Re: 117 Auburn Street

SHEET TITLE:
PARKING LOT LIGHTING
E0.1

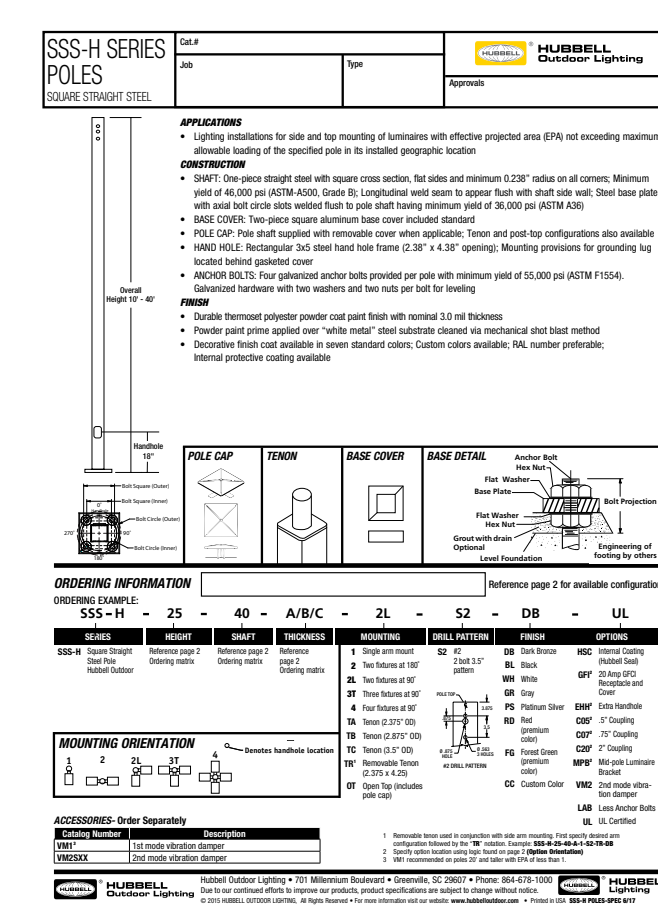
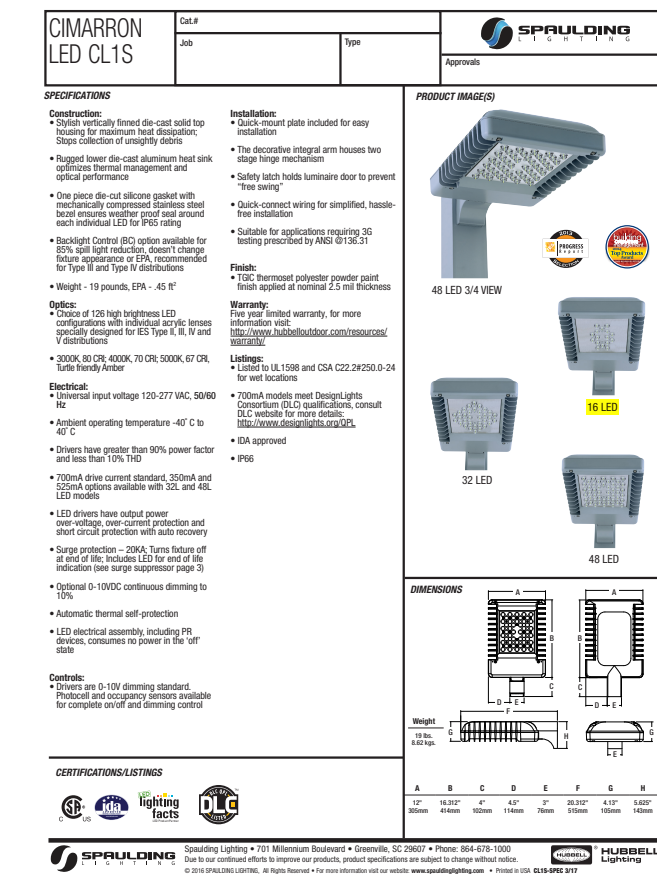
I am going to put in the file this is approved with the condition that light levels are reduced to 50% for the night.

I looked at the lighting plan and it meets our standards, so I am ok with the proposal. The technical standard calls for turning lights off after closing or dimming them to 50%. Do you know whether the client intends to turn the lights off or maintain some light levels during the night? Please let me know.

The owner is planning on maintaining the 50% level of lighting after closing time.
